**Planning Application No: 3/2024/0079**

**Proposal: Demolition of existing garage and construction of single and two-storey extensions to rear, front and rear dormers and new front porch. Resubmission of application 3/2023/0698.**

**Location: 302 Pleckgate Road Ramsgreave BB1 8QU**

PROPOSED SITE PLAN

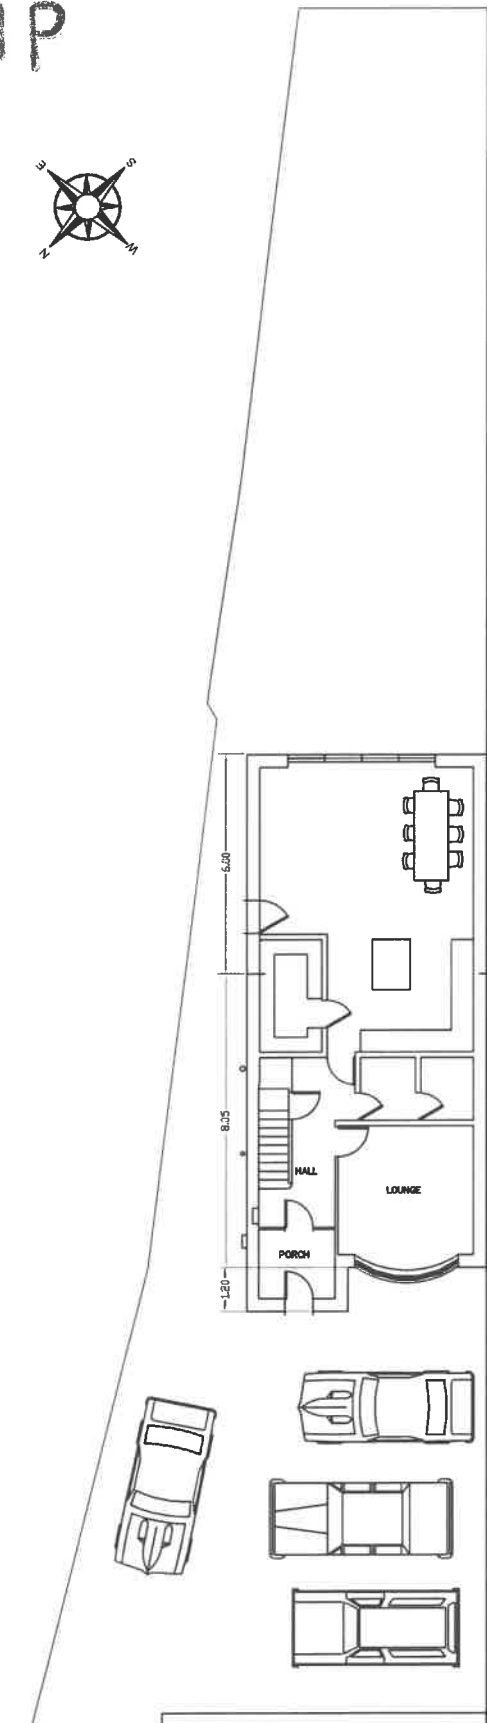
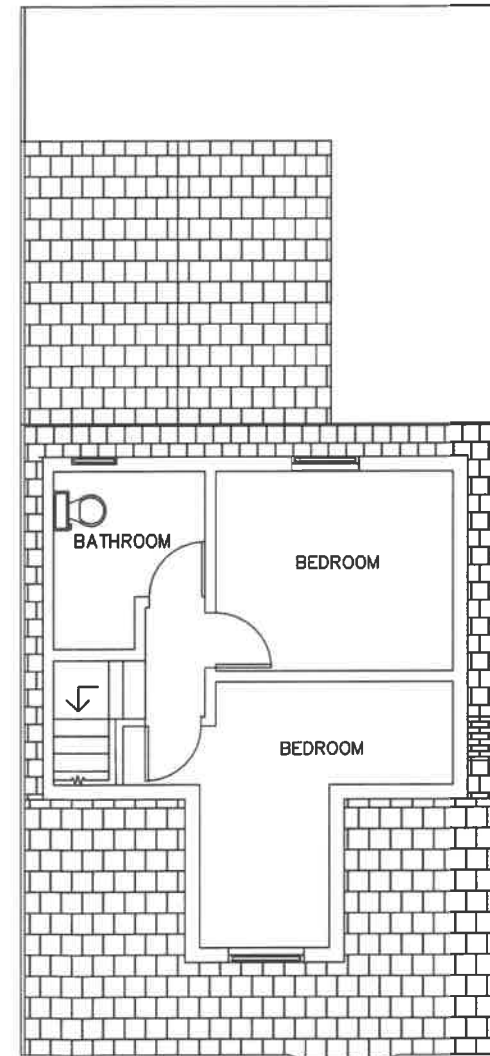
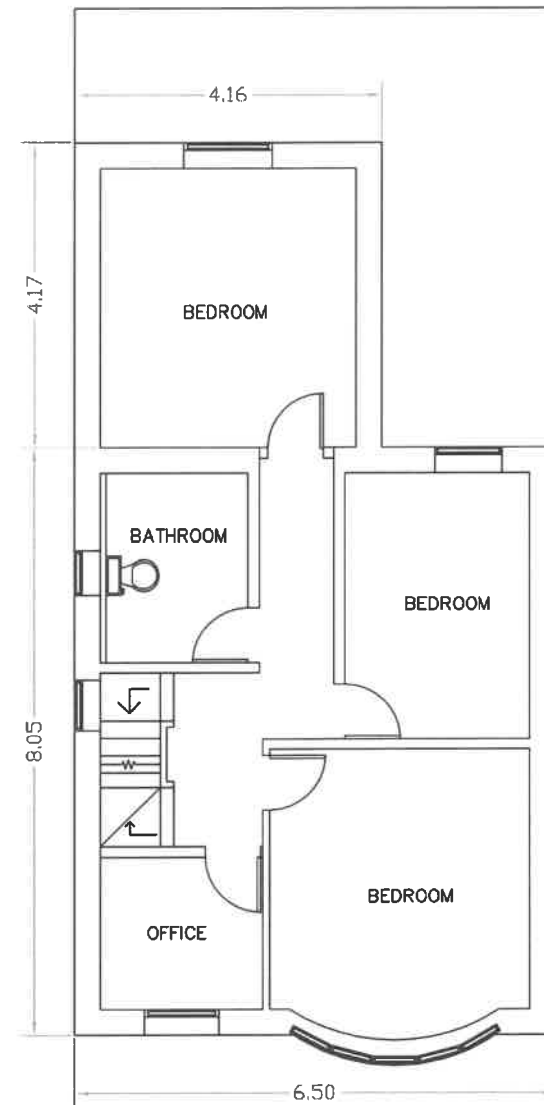
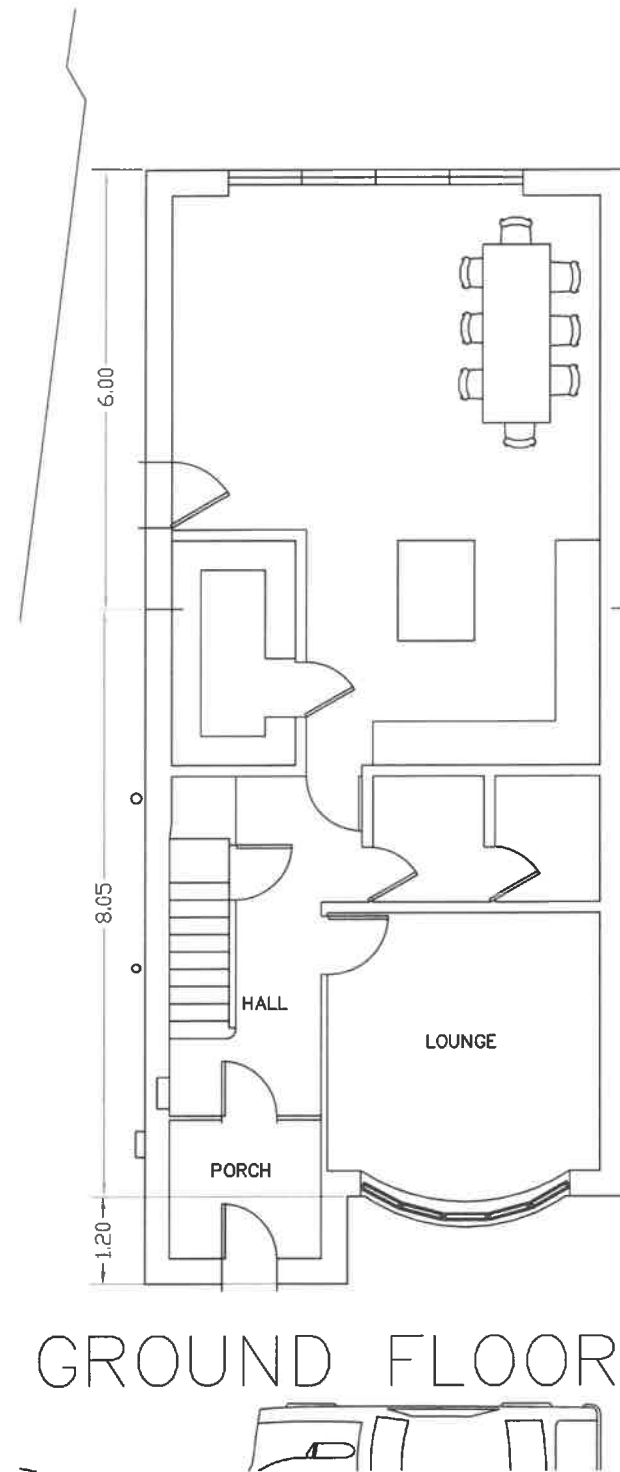
Ref Design and Access Statement Inclusive access There is no separate access to the rear of the site, all access to the property is via the front driveway. The vehicular crossing must be the full width of the drive, in order to prevent damage to the f/w.

- The parking areas must be constructed of a bound porous material and created before first occupation up until the lifetime of the dwelling existing in its proposed state. Reason: To ensure that satisfactory parking is provided before the dwelling hereby permitted becomes operative.
